303-C-1

3 Newcomb St.

Garage

**CITY OF PORTLAND, MAINE
DEVELOPMENT REVIEW APPLICATION
PLANNING DEPARTMENT PROCESSING FORM
Planning Copy**

3 MINCOMB ST.
PROPOSED SITE DRAINAGE PLAN
SCALE 1"=10' 5/8/01

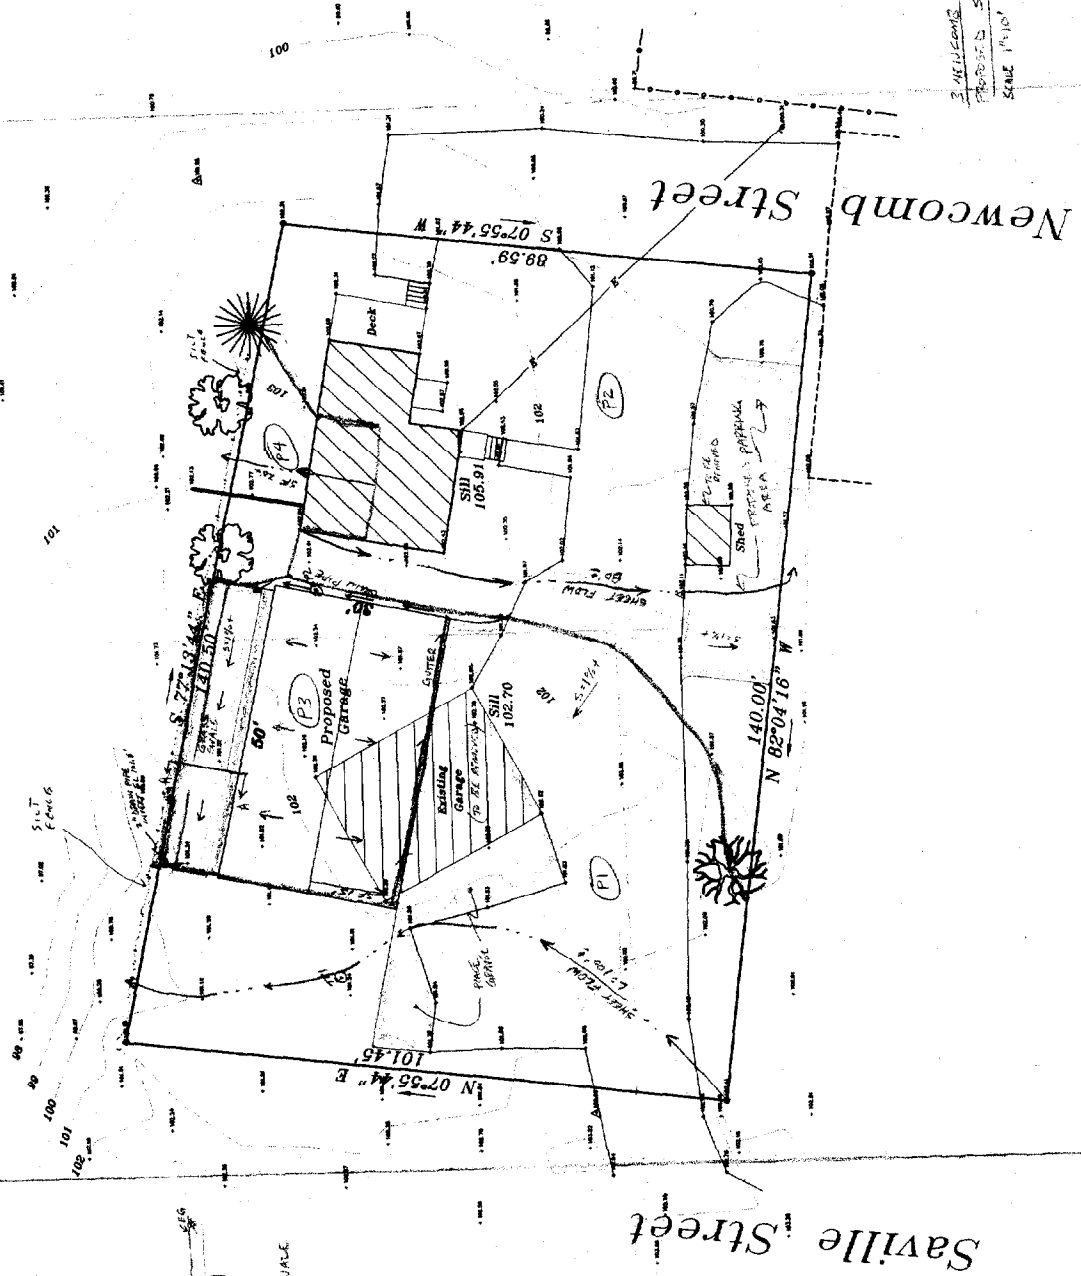
I understand a drainage swale has been placed two feet from my property line. What assurance can the City provide me that water from this swale will not leak onto my property. This would result in a condition prohibited by state law and city regulations. I suggest this swale be moved to a more expedient location and should the water flow figures for the twenty-five year storm show it, a retention pond should be required.

Since the new garage plans show a burning toilet, a better solution would be to require a regular toilet and the two properties, home and garage, be connected to the Warren Ave. sewer over unpaved Saville Street. A correct sizing of the pipe would be beneficial to the two existing properties on Saville Street. Perhaps this would be an ideal opportunity to measure the efficiency of the septic systems of these two properties.

I've looked at both plans and find them to be consistent with each other and compliant with our standards for stormwater management.

In both cases, we required a low swale for detention in order to retain runoff in the case of a rain event. The swale on your property was designed to catch runoff from the roof of the garage building, before outletting it the rear of the site. The Delta Realty plan, which was prepared by a civil engineer, was also designed with a swale to catch runoff between the existing developed portion of the site and the new storage building. The 100 foot long swale is, like yours, designed with a 1% slope to provide slight retention and direction of the flow. Their plan directs the stormwater to a low area on their own property, adjacent to the railroad right of way.
